# **KITITAS COUNTY**

## **DEPARTMENT OF PUBLIC WORKS**

TO: All Staff  
FROM: Justin Turnbull, County Surveyor   
DATE: July 1, 2020  
SUBJECT: County Survey Review of BL-20-00017 Moore

LOTS 4, 5 & 6, HYAK ESTATES DIV. 2  
 LOCATED IN THE NORTHWEST QUARTER OF SECTION 15,  
 TOWNSHIP 22 NORTH, RANGE 11 EAST, W.M.

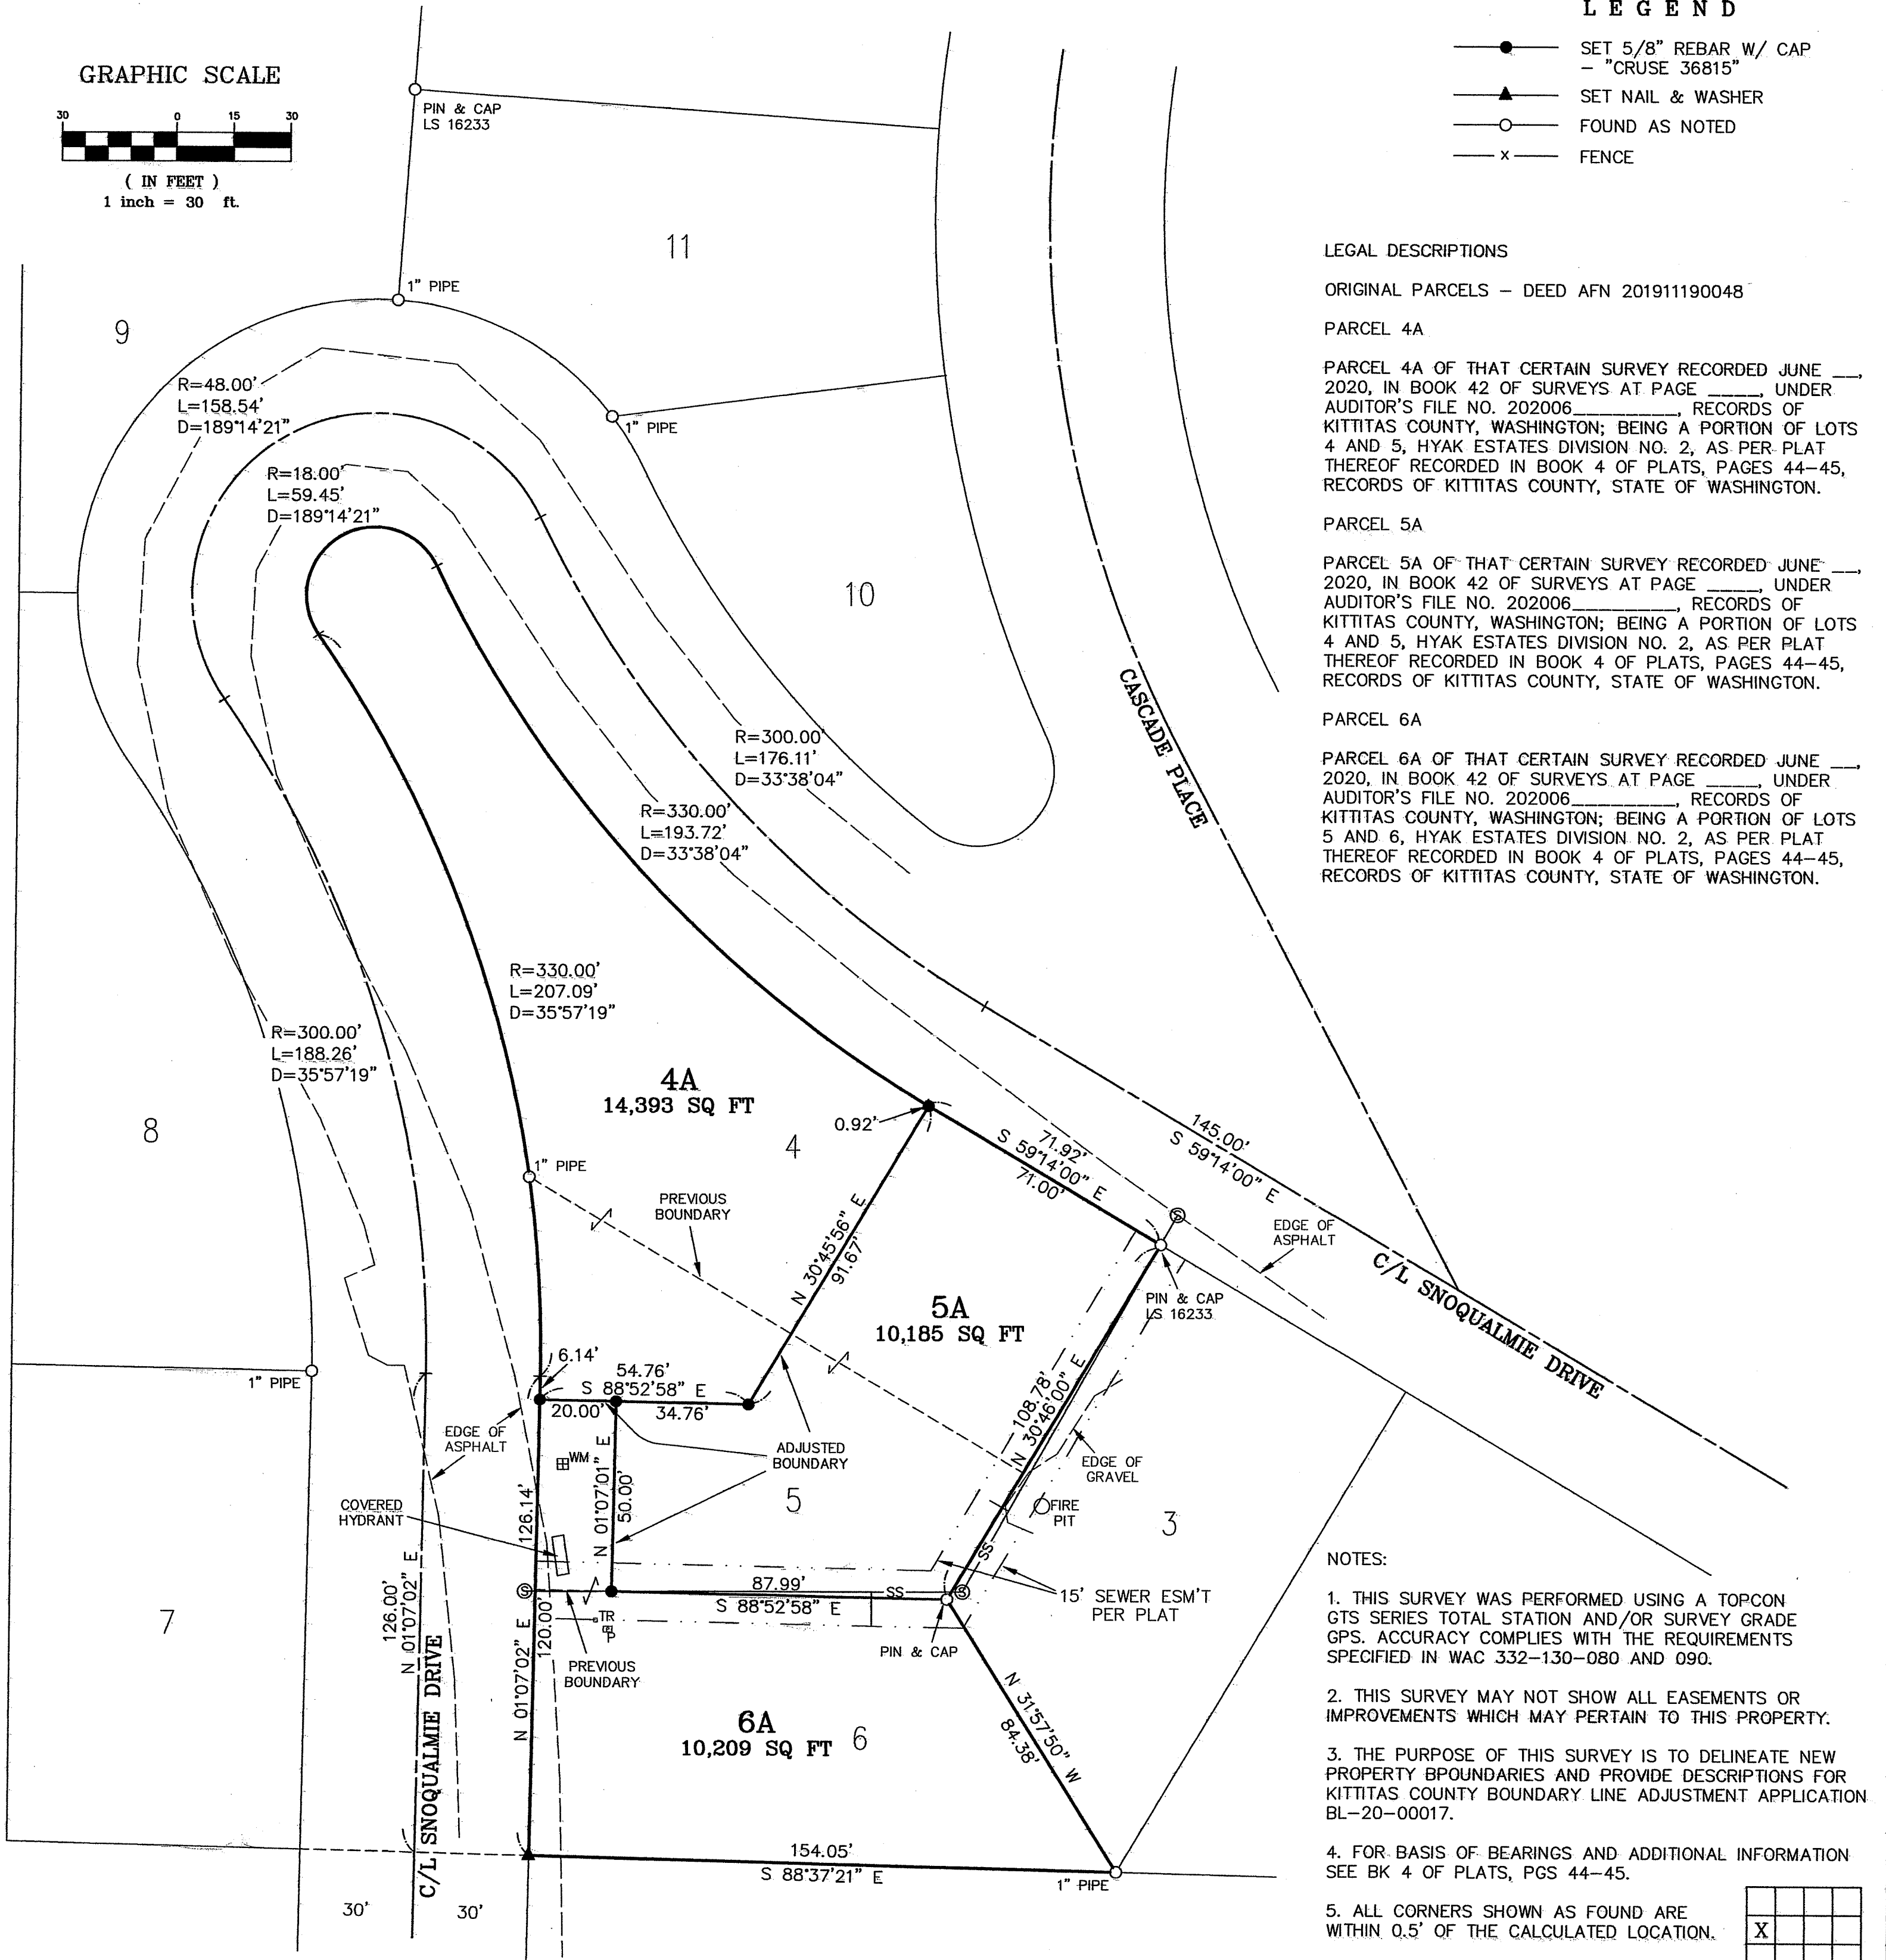
1. Date of recording within the legal descriptions is out of date.
2. Note 3 contains spelling typo.
3. Note 4 references a Plat that has not addressed basis of bearing.
4. The combination of Note 4, Note 5 and the use of property corners as controlling monuments may make accurate retracement of this survey difficult without knowing what specific corners were utilized as survey control.
